**From:** Daun Johnson on behalf of Planning.Responses  
**Sent:** 05 April 2018 08:38  
**To:** Planning Scanning  
**Subject:** FW: Planning Consultation on FG/48/18/DOC

Comments relating to Condition 4 Drainage:

**APPLICATION NO:** FG/48/18/DOC

**Description of Works:** Application for approval of details reserved by condition imposed under planning permission FG/37/17/PL relating to condition No. 4 (Surface water drainage) & 6 (Construction management plan)

DRAINAGE PLAN - PLANNING
CONDITION 4

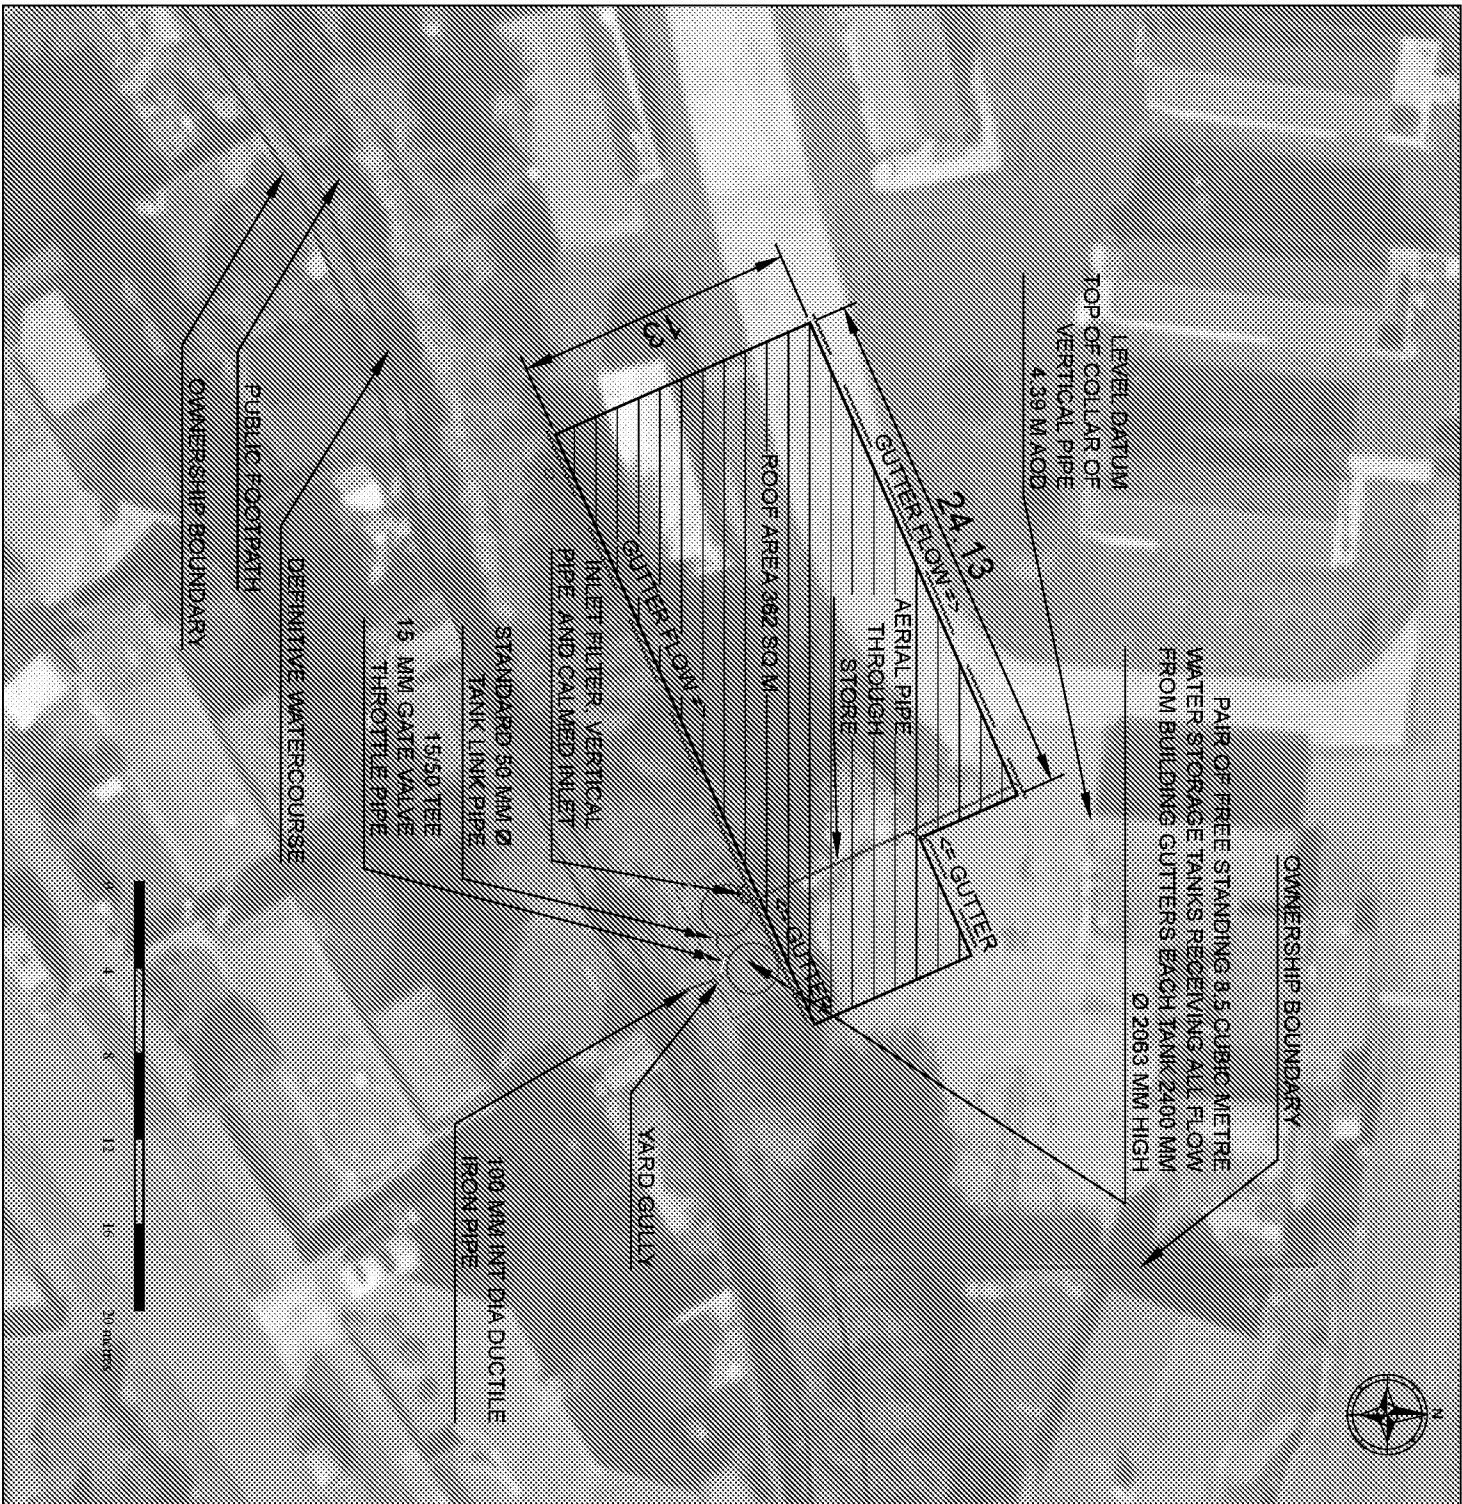
- It is noted that only a 20% allowance for climate change has been included in the design of the surface water drainage system. This needs to be increased to 30% in line with the condition applied.

- Storm durations from and including 15 minutes need to be used.
  - The restriction size of 20mm is of concern regarding the possibility of blockage. It is recommended that a mesh or similar is installed within each tank at the face of the outlet.

- It is currently proposed that the outlet to the existing ditch will be formed by a paving slab. This is not acceptable, we require a formal headwall to be formed using concrete bags or brickwork. With full construction detail drawings to be supplied and approved by us.

- Full construction details will be required including the gully/headwall, any manholes, and silt traps.
- I will comment further once revised calculations and drawings have been provided.
